From: Amanda Scholes on behalf of Planning.Responses
Sent: 27 July 2020 08:12
To: Planning Scanning
Subject: FW: FW: FW: Planning Consultation on: BN/57/20/DOC

Please upload onto Ocella the email below which is the further consultation response from **ADC Drainage Engineers** to discharge of condition application **BN/57/20/DOC**.

Condition 6 – Surface Water Drainage Design

PERMEABLE BLOCK PAVING CONSTRUCTION

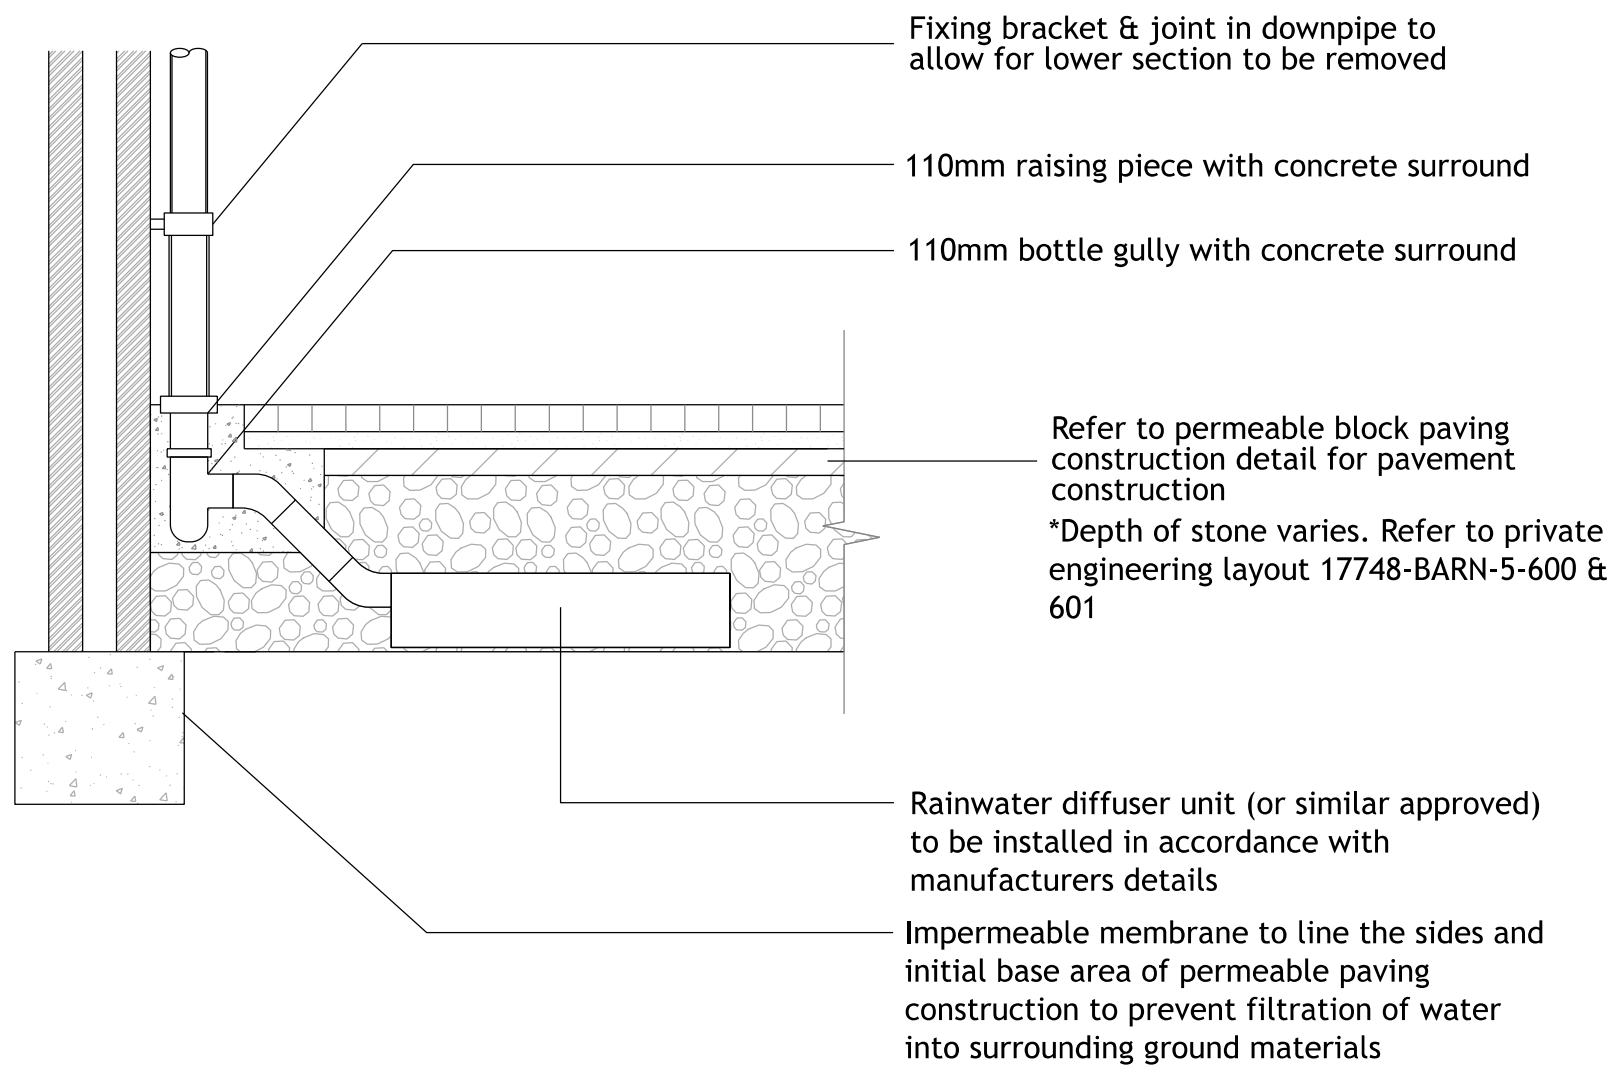
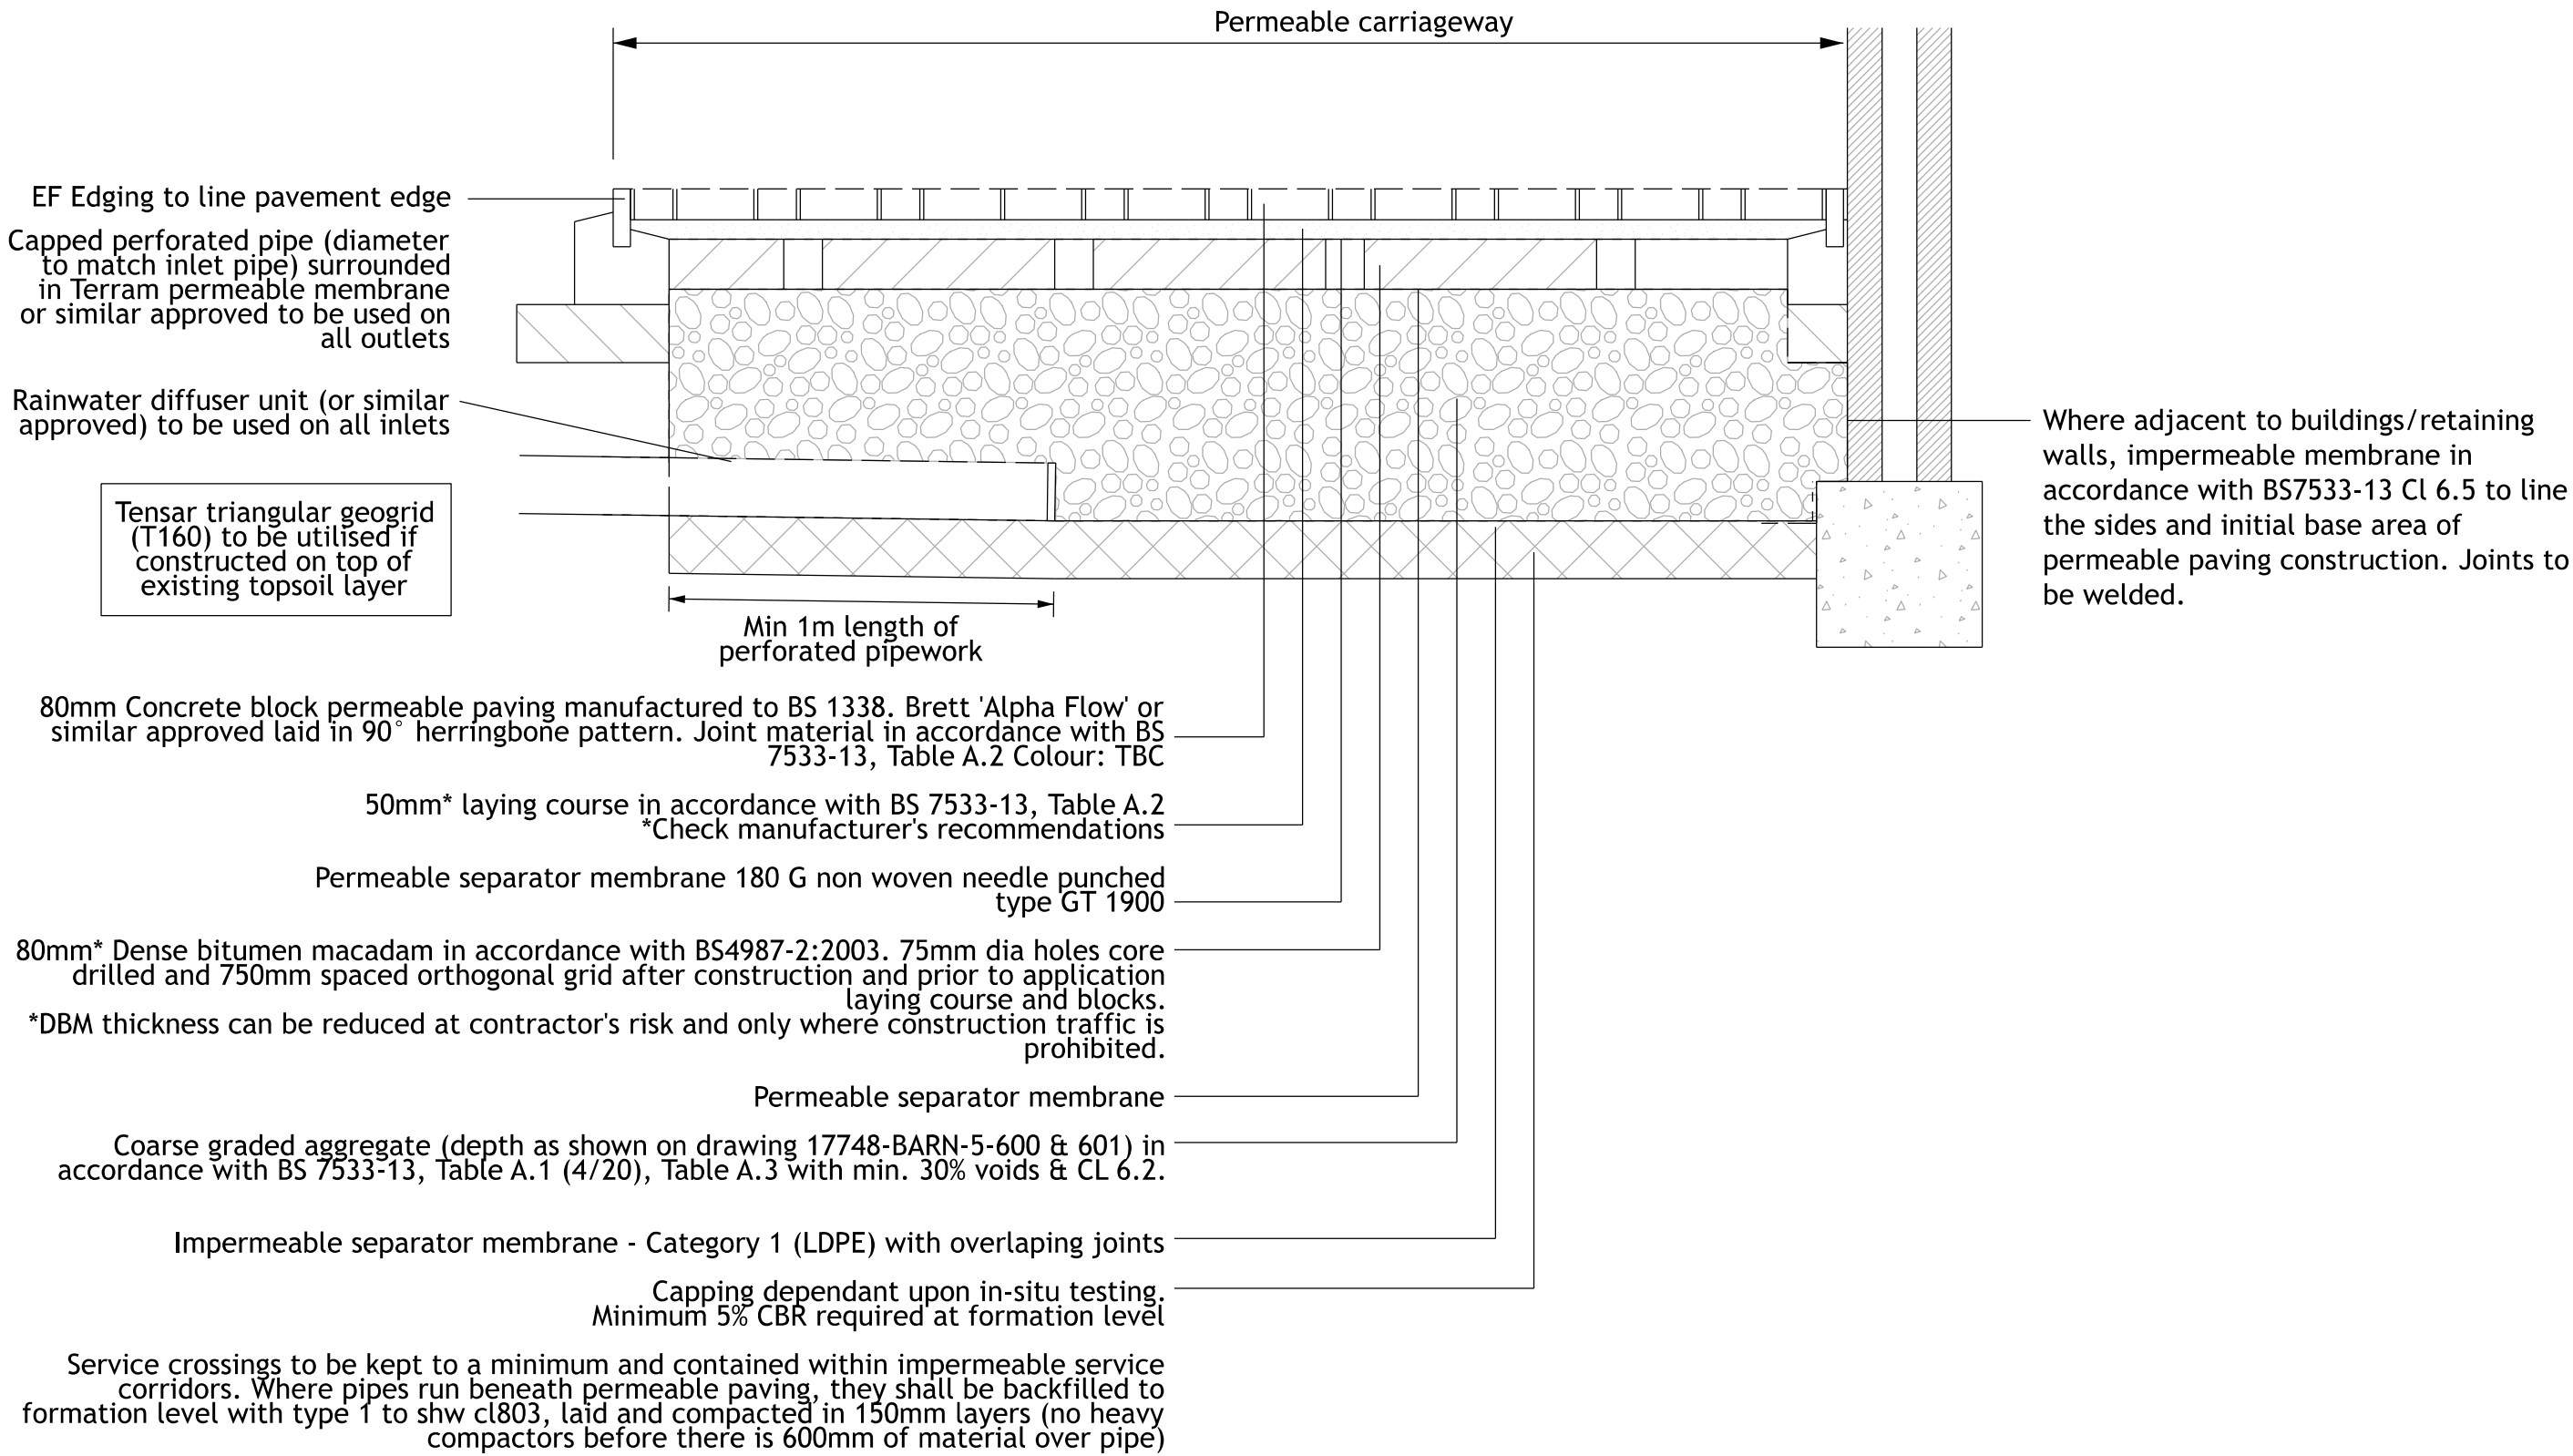
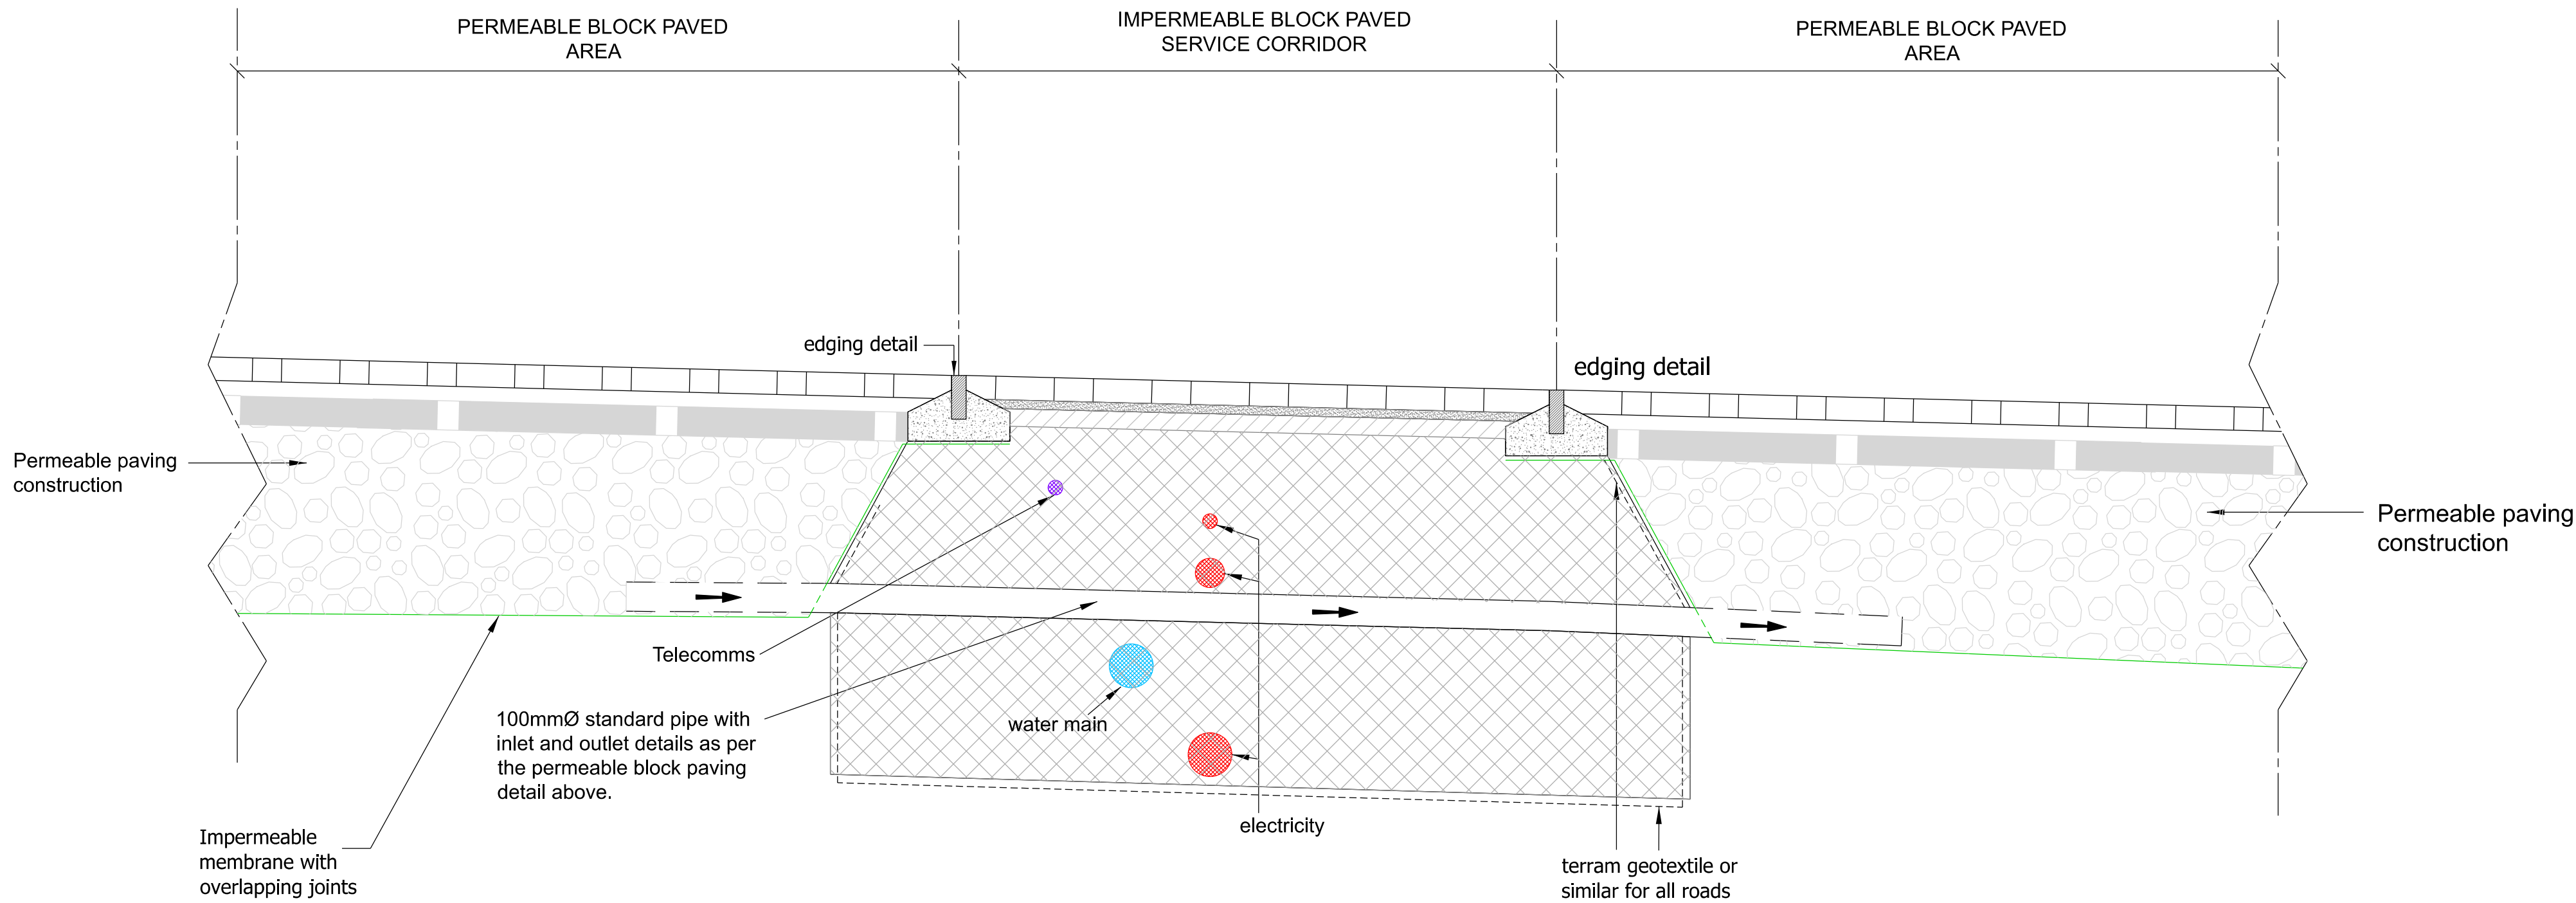
14. Include invert levels and dimensions of connecting pipes between permeable paving areas. For example the link pipe between M4 permeable paving areas near plots 7 and 6 does not have a diameter or upstream invert level. *This is shown on the private permeable paving construction details Drawing 17748-BARN-5-921 and dealt with in correspondence with Paul Cann. Drawing not included on planning website or in correspondence regarding this DOC application, please provide, all documents must be publically available and be able to be referenced in any approvals.*

15. Detail how water will flow between sub-base either side of service corridor construction for foul sewer. *This is shown on the private permeable paving construction details Drawing 17748-BARN-5-921 and dealt with in correspondence with Paul Cann. Drawing not included on planning website or in correspondence regarding this DOC application, please provide, all documents must be publically available and be able to be referenced in any approvals.*

22. Permeable paving construction detail drawing required. *Drawing 17748-BARN-5-921 Please supply details, as stated previously by others sufficient information to ensure construction has been completed in accordance with approvals is required.*
